DOC17/303859

Narrabri Gas Project (SSD 6456)
Comment on the Environmental Impact Statement (EIS)

Figure 3-1 Groundwater monitoring locations in the Gunnedah-Oxley Basin

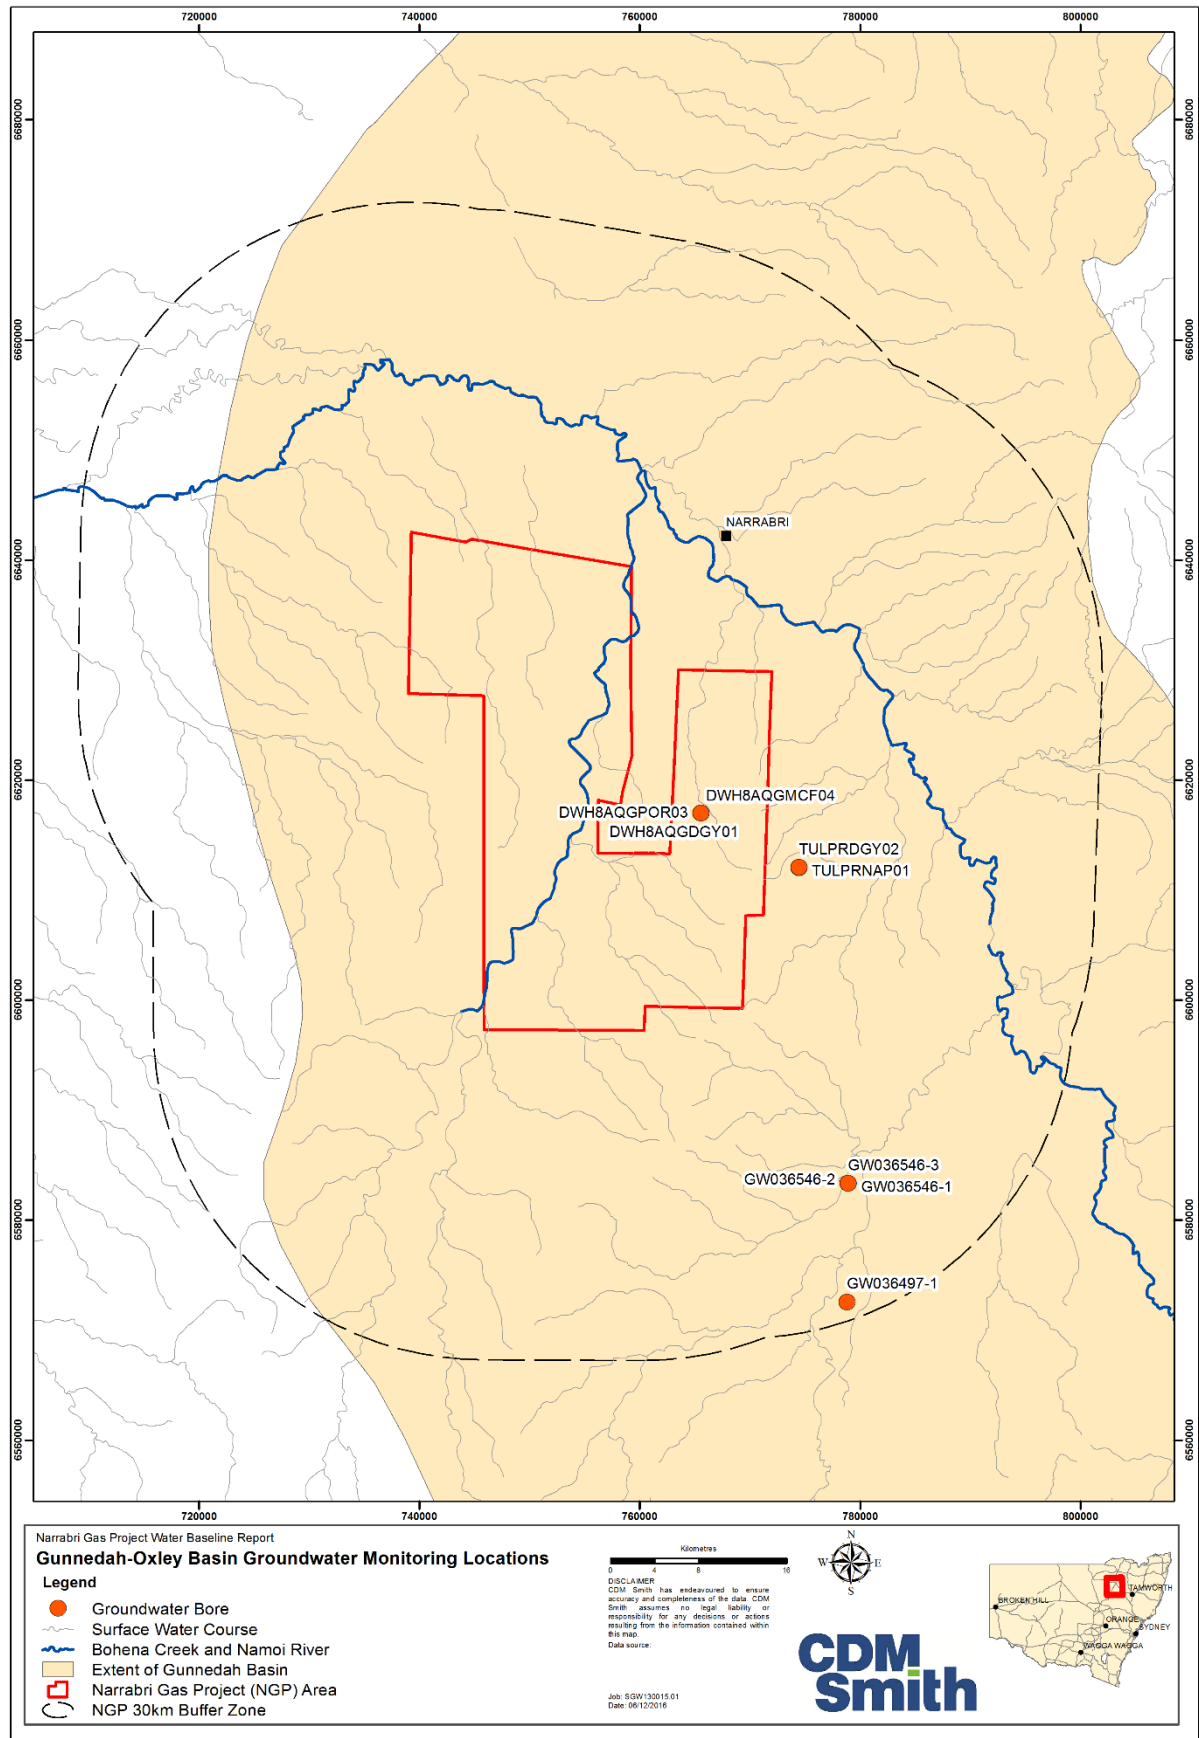
Groundwater quality within the GOB, both to the west of and within the NGP area, could be better characterised by the baseline datasets. Figure 3.1 (p3-4) of the G4 Water Baseline Report illustrate this data gap with large parts of the NGP area and the Basin uncovered by baseline monitoring. Additionally, only two of these monitoring sites (which both lie outside the NGP area) contain datasets for groundwater quality.

The EPA recommends additional water quality baseline monitoring points be installed and sufficient baseline dataset be collected to address groundwater quality prior to installation of gas wells in each area across the western area of the Gunnedah Oxley Basin and within the Narrabri Gas Project area.
